Ribble Valley Borough Council
Housing & Development Control

Application no: **3/2023/0164**

Address: **Garages to rear of 28 Coniston Close Longridge PR3 3AU**

Proposal: **Demolition of existing garage block and erection of new single storey dwelling.**

NEW DWELLING: LAND OFF CONISTON CLOSE, LONGRIDGE, PRESTON LANCS PR3	JM-0262	003	Rev-C
	PROPOSED SITE & FLOOR PLANS		Date: 27.01.23 Drawn: J Monks Scale: 1:100/200 Size: A3
MONKS-ARCHITECTURAL-DESIGN 25 BIRCHFIELD DRIVE - LONGRIDGE- PRESTON - PR3 3HP

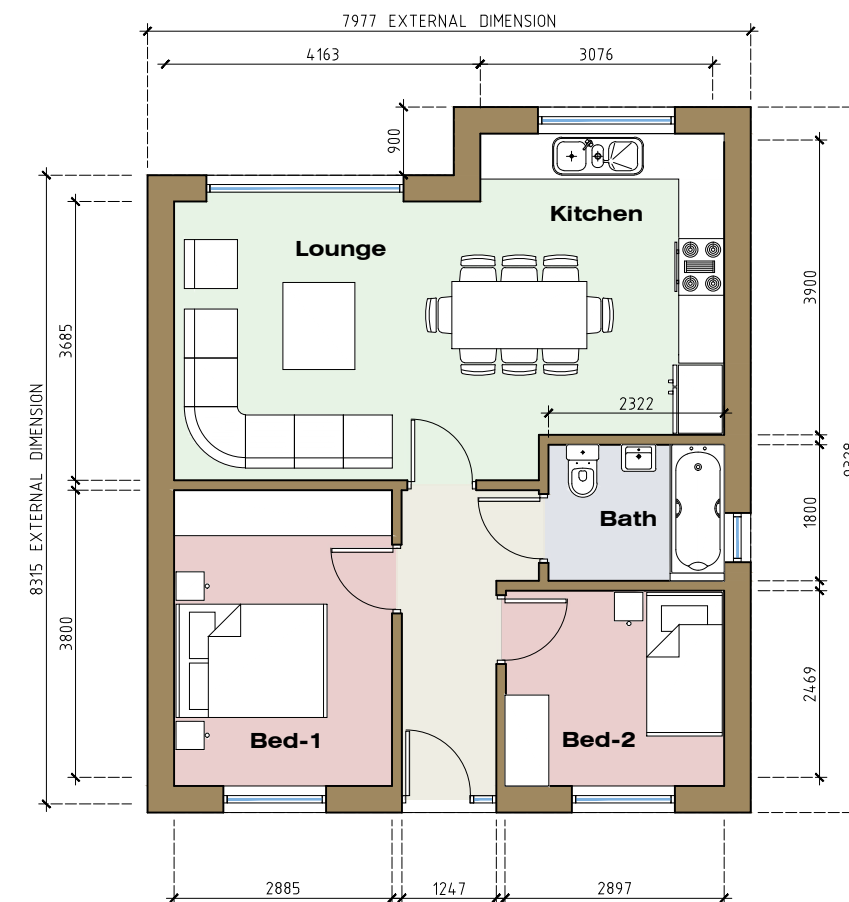
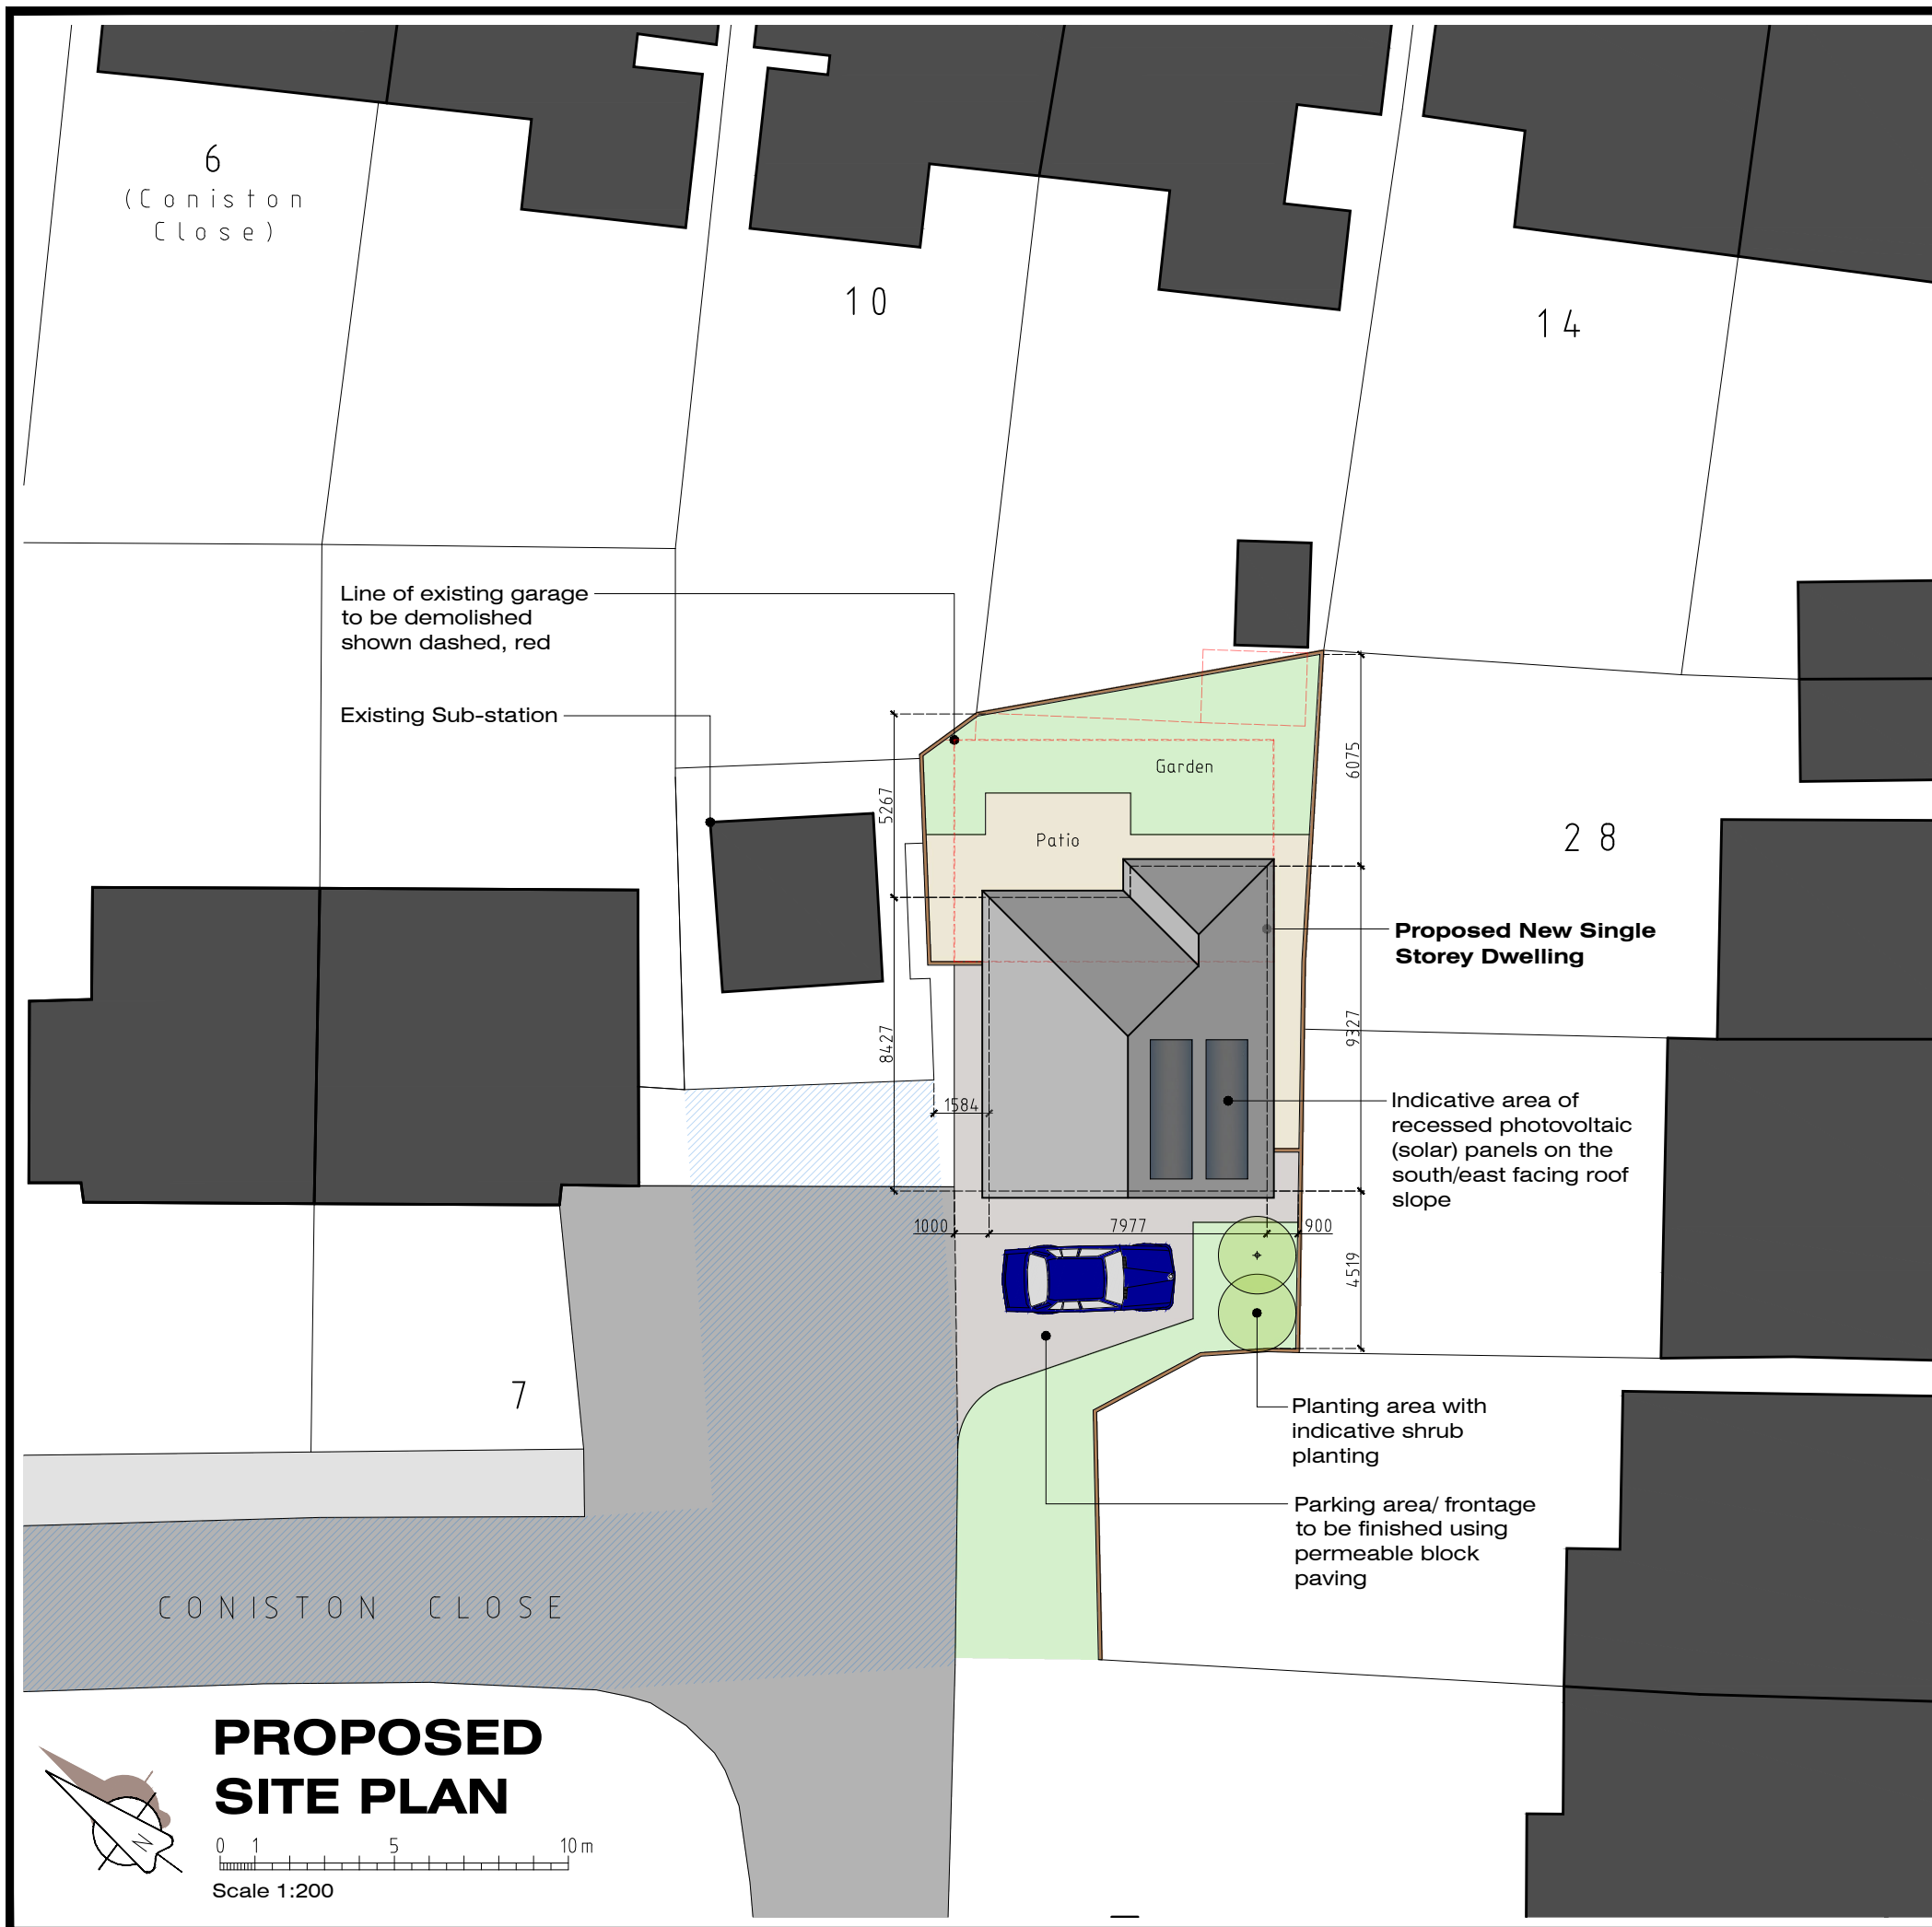
The LHA have reviewed Monks drawing number JM-0262-003 Rev C titled "Proposed Site and Floor Plans" and are aware that the access width complies with the LHAs guidance when serving a single dwelling.

However, given the access is located off an unadopted road, which is likely to be owned by the statutory undertaker who owns and/or maintains the adjacent sub-station, the LHA require further information as to whether the site has the right to use the unadopted piece of land when accessing the site.

A short statement should detail whether the statutory undertaker has given permission for the Applicant to use the unadopted hardstanding area when accessing and egressing from the site onto Coniston Close.

The LHA have reviewed Monks drawing number JM-0262-003 Rev C titled "Proposed Site and Floor Plans" and are aware that one car parking space will be provided for the proposed 2 bed dwelling. This does not comply with the LHAs parking guidance, as defined in the Joint Lancashire Structure Plan, which requires the site to provide 2 car parking spaces.

Unfortunately, given that the proposed dwelling is adjacent to the access to the sub-station which needs to be clear at all times for statutory undertakers to access, the LHA require that 2 car parking spaces are provided.

The LHA advise that the planting area located at the front of the dwelling, adjacent to the proposed car parking space, is removed so that 2 car parking spaces can be provided in tandem on the proposed driveway. This should be shown on a revised plan.
